Rezoning Petition Review

Rezoning Petition #: 20-52

Location of Property: Approximately 1 acre located on the west side of the intersection of East Blvd and Scott Ave, east of Kenilworth Ave.

REVISIONS	
NO.	DATE
JOB #	20005
DATE	03/06/20
SCALE	1" = 20'
DRAWN BY:	JAW
APPROVED BY:	JCO
RZ 1.0

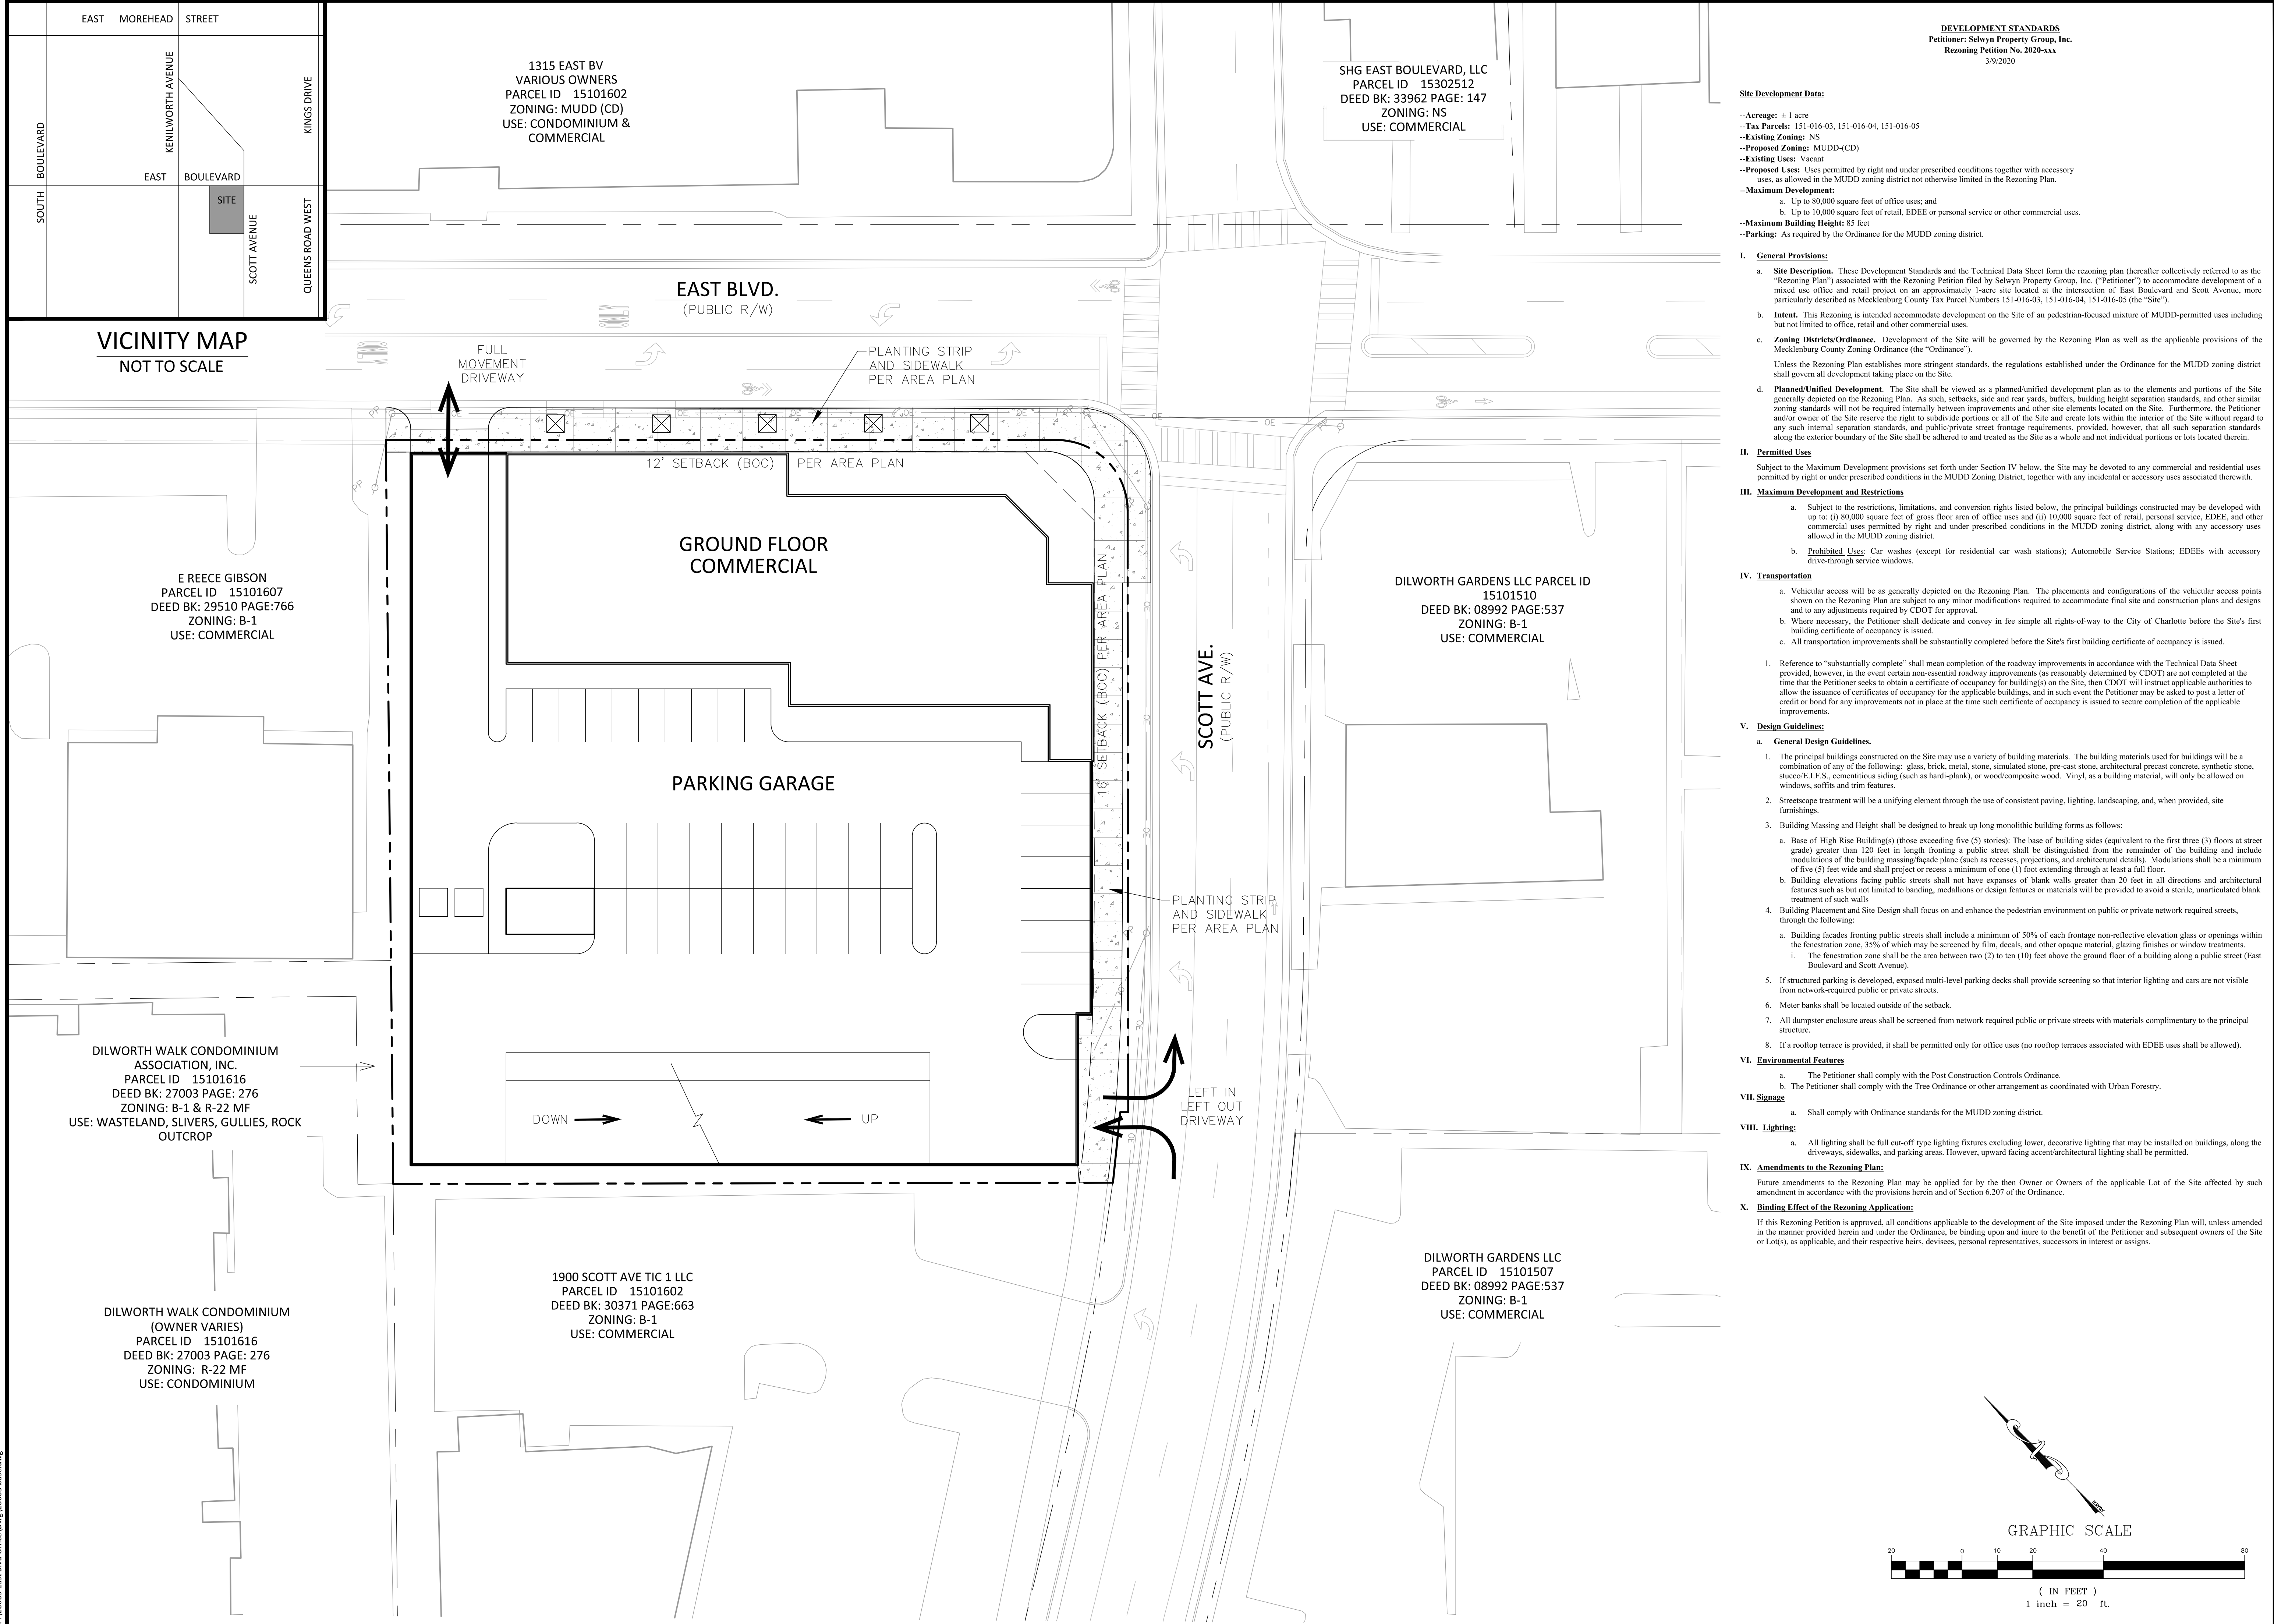
This property drains to Upper Little Sugar Creek, which is an impaired/degraded stream, and may contribute to downstream flooding. This project has the opportunity to mitigate future impacts to this stream, therefore, Storm Water recommends placing the following notes on the plan:

For defined watersheds greater than 24% built-upon area (BUA), construct water quality stormwater control measures (SCMs) designed for the runoff generated from the first 1-inch of rainfall for all new and redeveloped BUA associated with the project. SCMs must be designed and constructed in accordance with the Charlotte-Mecklenburg BMP Design Manual.

For defined watersheds greater than 24% built-upon area, control the entire volume for the 1-year, 24-hour storm for all new and redeveloped BUA associated with the project. Runoff volume drawdown time shall be in accordance with the Charlotte-Mecklenburg BMP Design Manual.

For commercial projects with greater than 24% BUA, control the peak to not exceed the predevelopment runoff rates for the 10-yr, 6-hr storm and perform a downstream flood analysis to determine whether additional peak control is needed and if so, for what level of storm frequency, or if a downstream analysis is not performed, control the peak for the 10-yr and 25-yr, 6-hour storms.
